OFFICIAL NOTICE OF DECISION

CITY OF ALBUQUERQUE
PLANNING DEPARTMENT
DEVELOPMENT REVIEW BOARD

9. Project # 1002821

RAY HENSLEY agent(s) for ESMAIL HAIDARI request(s) the above action(s) for all or a portion of Lot(s) 14, 15, & 16, Block(s) 14, NORTH ALBUQUERQUE ACRES, TRACT 3, UNIT 2, (to be known as **TALEA COURT SUBDIVISION**) zoned R-D, located on CORONADO NE, between EUBANK NE and HOLBROOK NE containing approximately 3 acre(s). [REF: SD-89-1, AX-92-114, Z-89-114] [*Deferred from 8/13/03*] (D-21)

PRELIMINARY PLAT
 FOR
 TALEA COURT SUBDIVISION
 LOTS 14, 15 AND 16
 BLOCK 14
 TRACT 3, UNIT 2
 NORTH ALBUQUERQUE ACRES
 CITY OF ALBUQUERQUE
 BERNALILLO COUNTY, NEW MEXICO
 JULY 2003

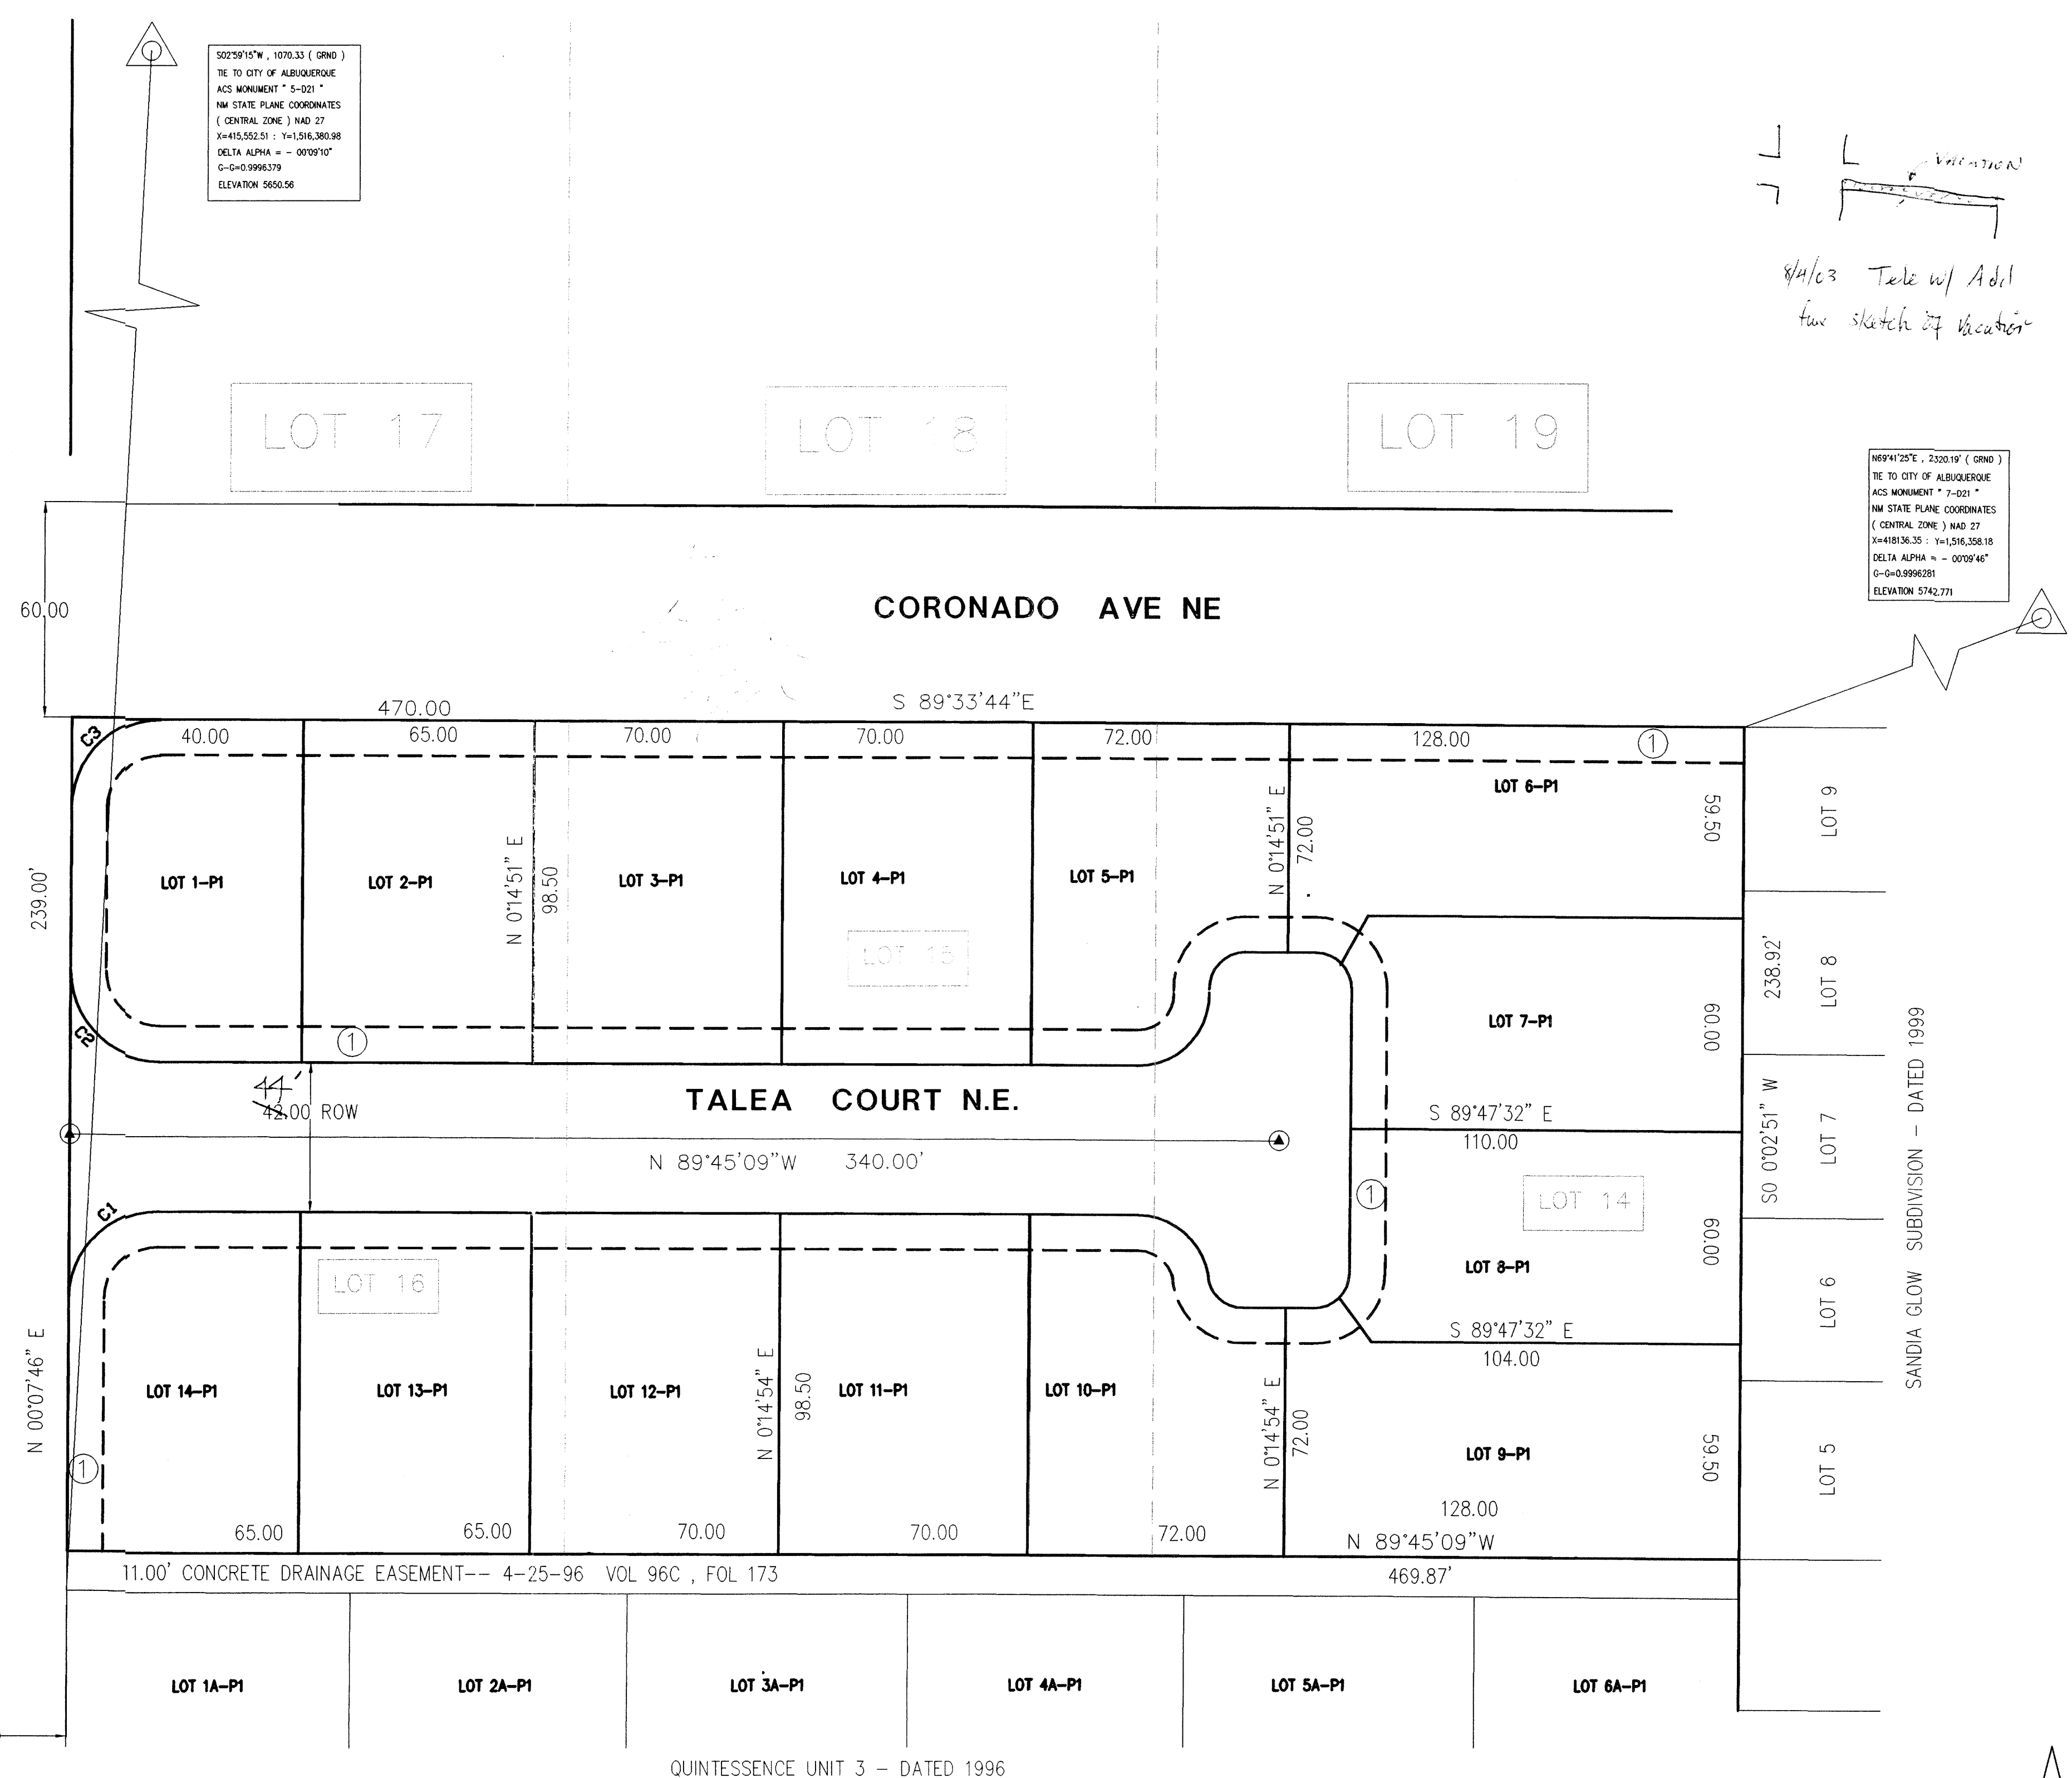
1. The fire department must concur with the dimensions for the cul-de-sac.
